Fosse Green Energy Solar Farm (EN010154)

Deadline 4 / 5 Submission by Thurlby Parish Meeting

1.1 This submission is made by Thurlby Parish Meeting in response to the Applicant's "Response to Deadline 3 and 3A Submissions" (Document 9.24), and in particular the response to REP3-060.

Indicative PV Array Cross-Sections

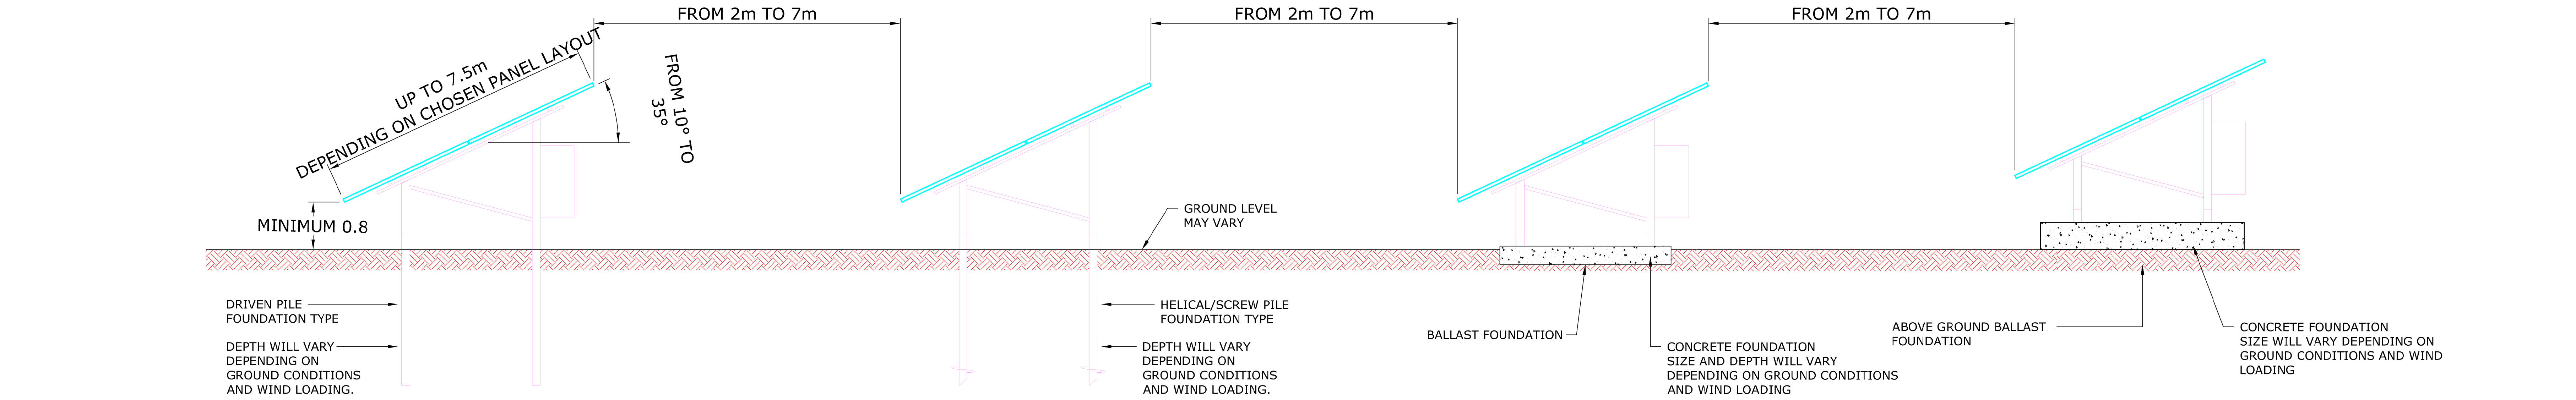
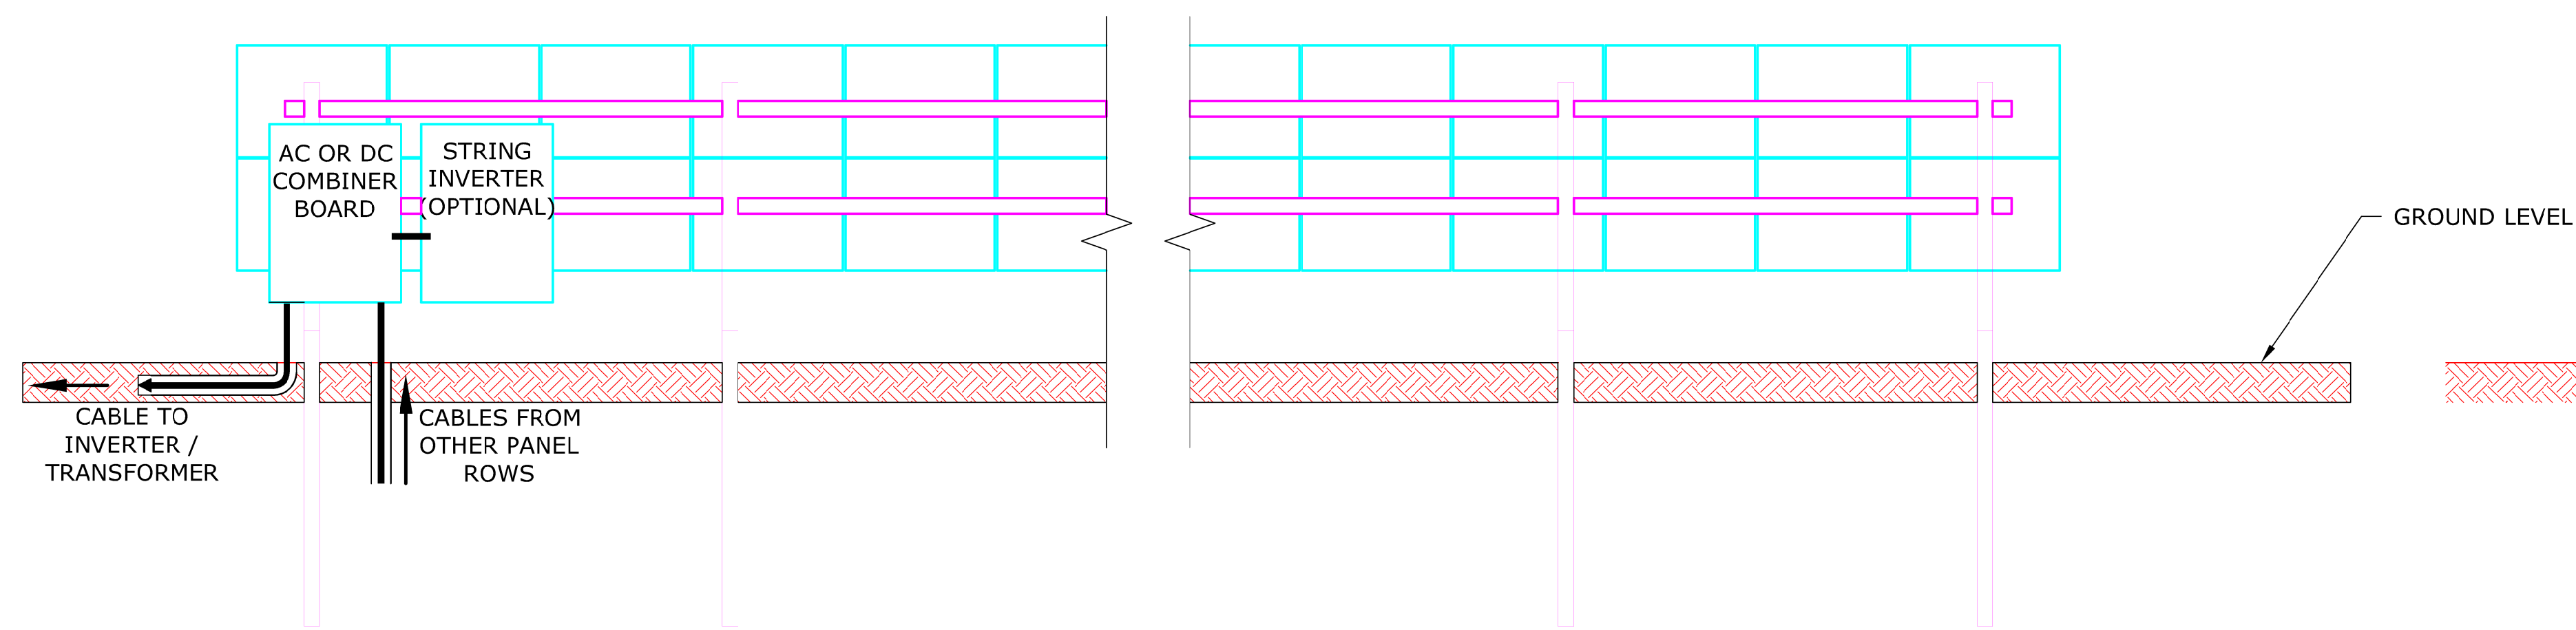
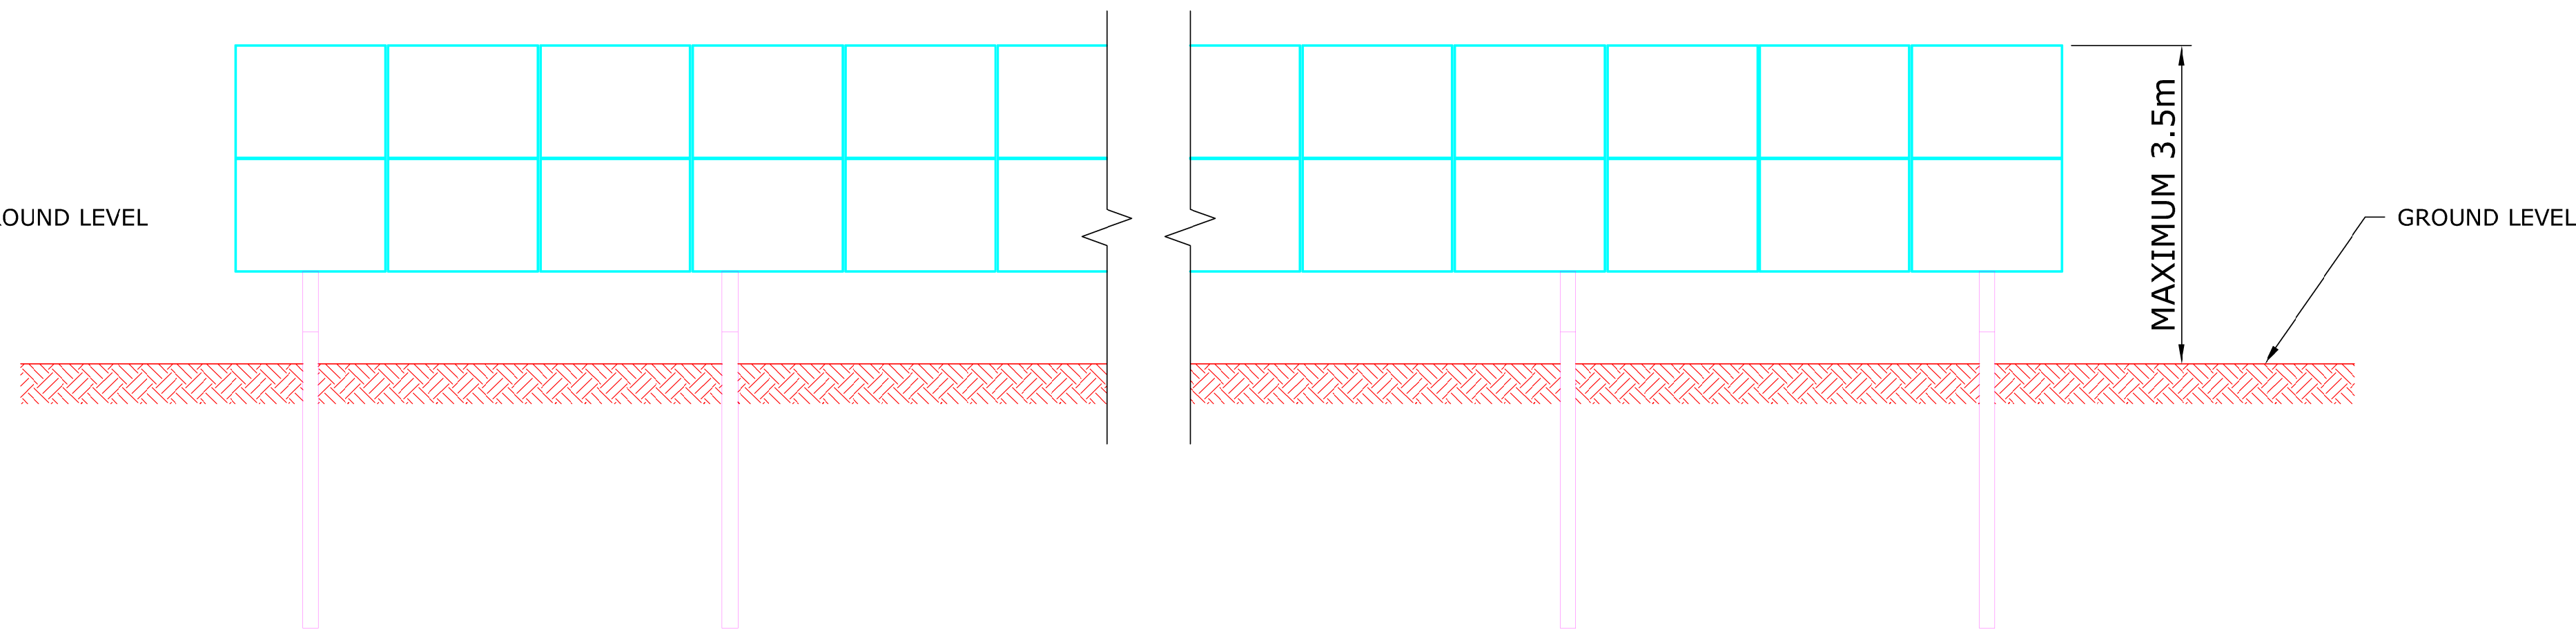
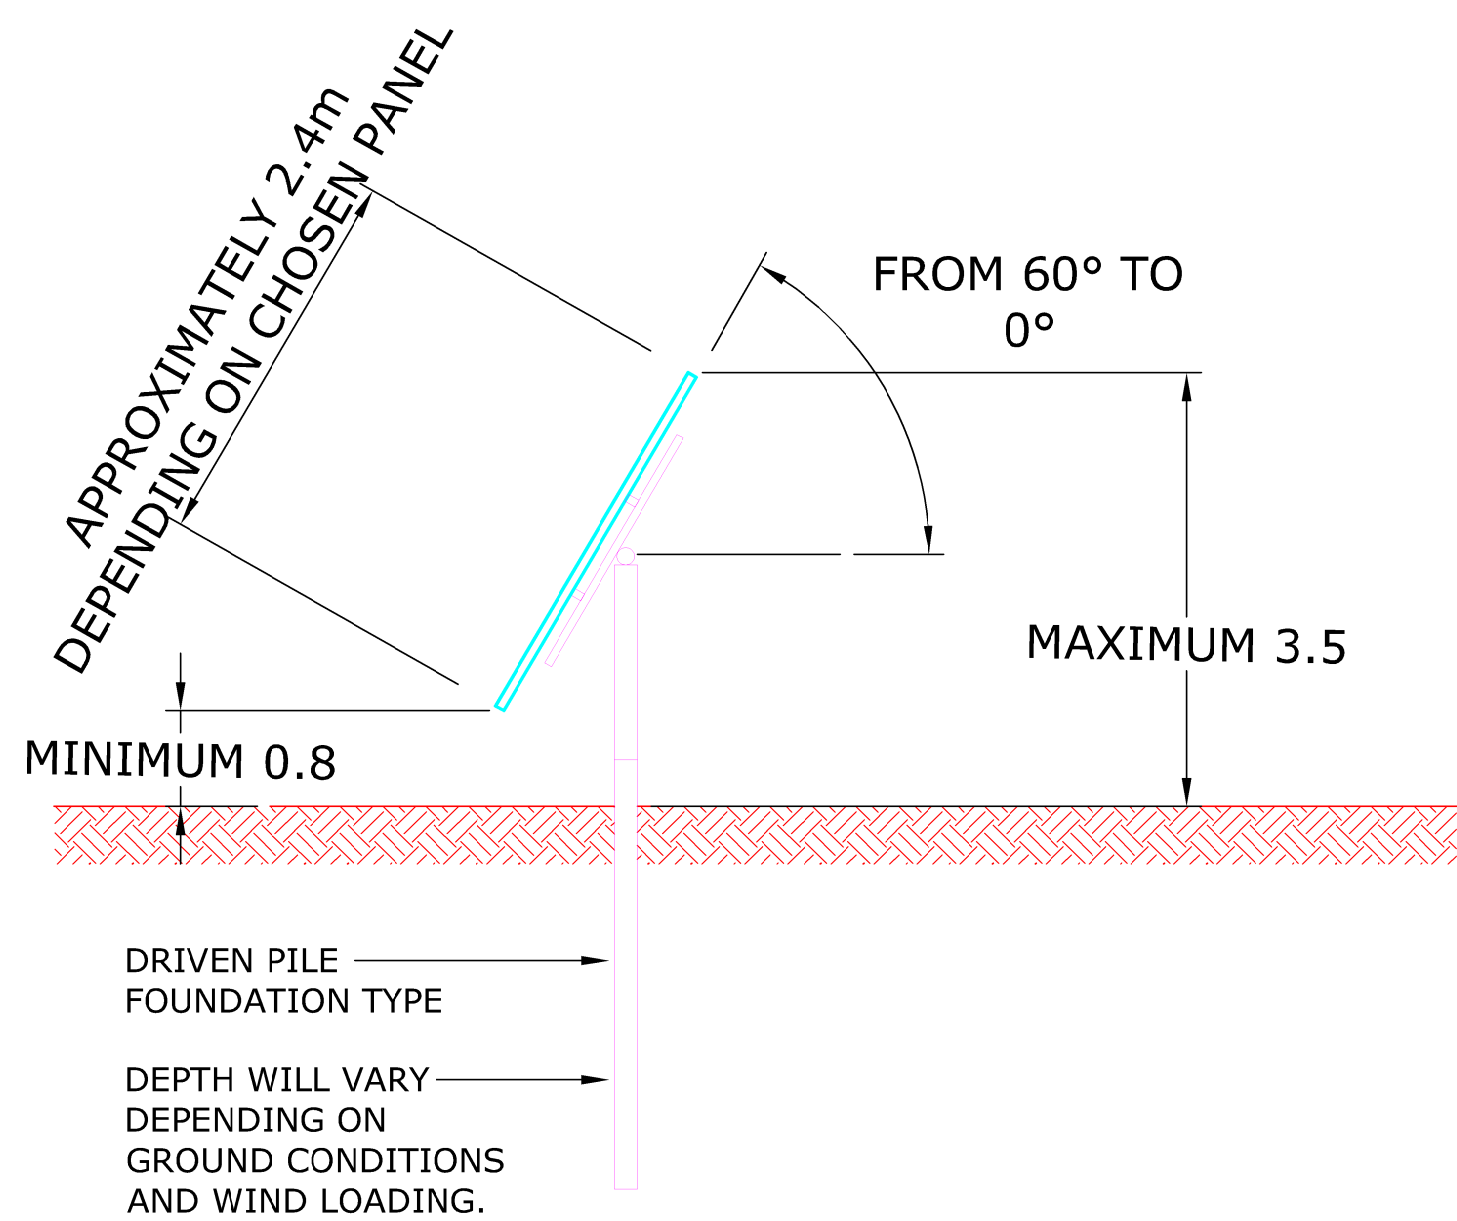
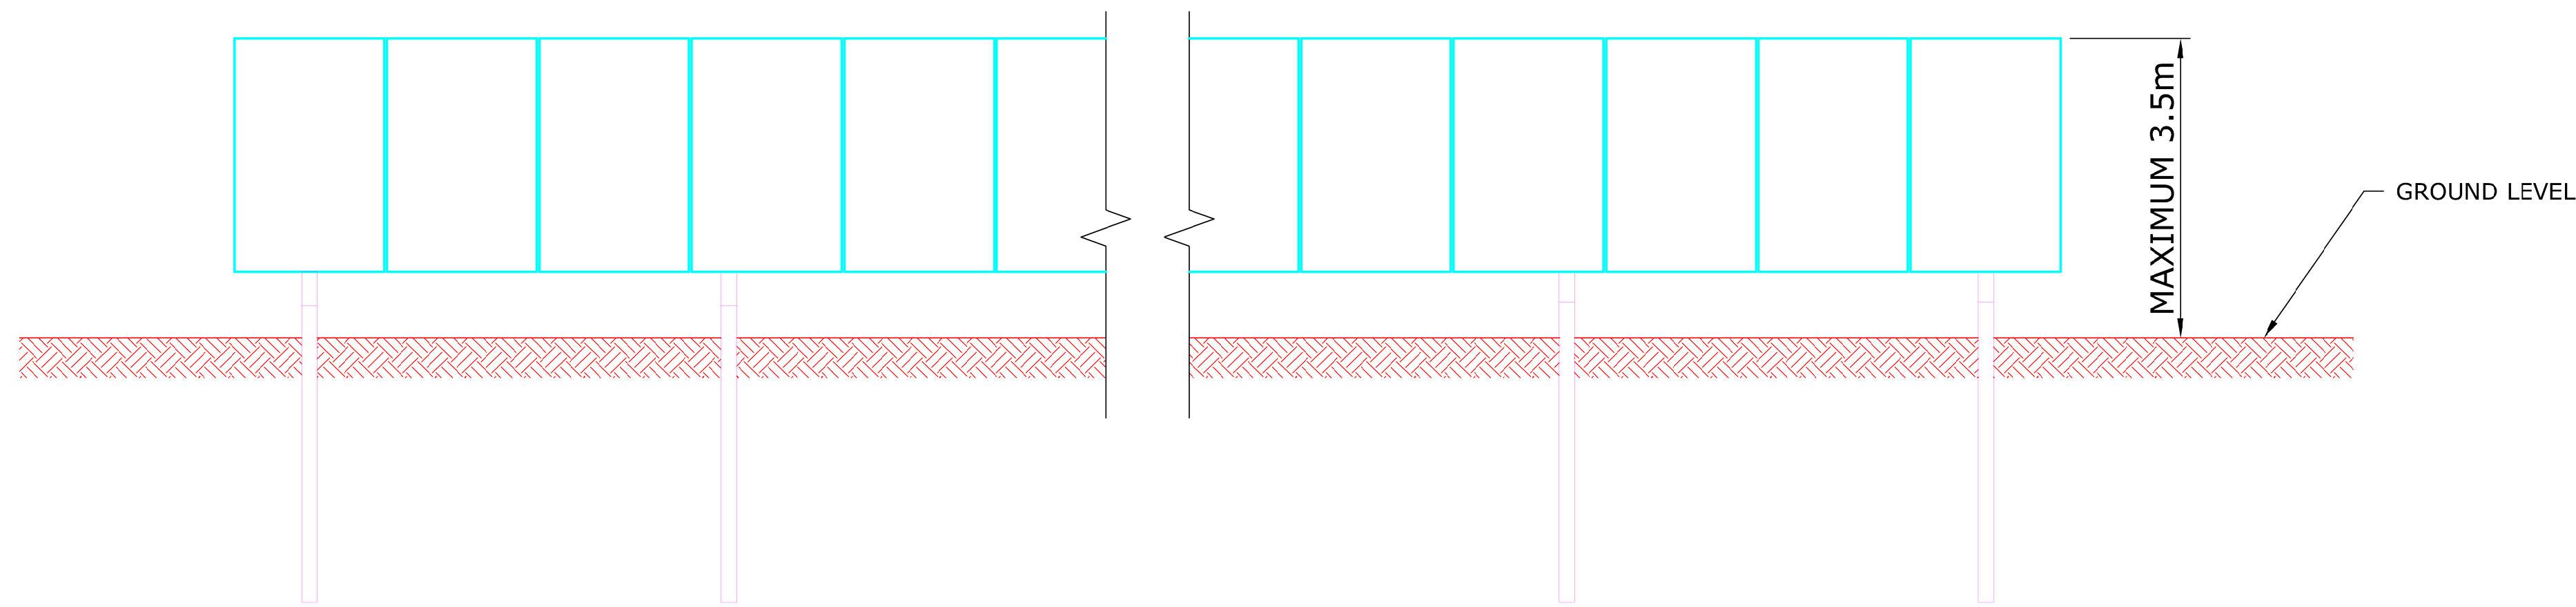
- Solar panels shall not exceed **3.5 metres in height above ground level**
- Battery Energy Storage System (BESS) units shall not exceed **4.0 metres in height**
- BESS shall only be located within the areas identified on Parameter Plan - BESS Zones
- The total developable area within each land parcel shall not exceed **70% coverage** (excluding landscaping buffers)

These values reflect the **upper limits assessed within the Environmental Statement**, and ensure the built scheme cannot exceed assessed impacts.
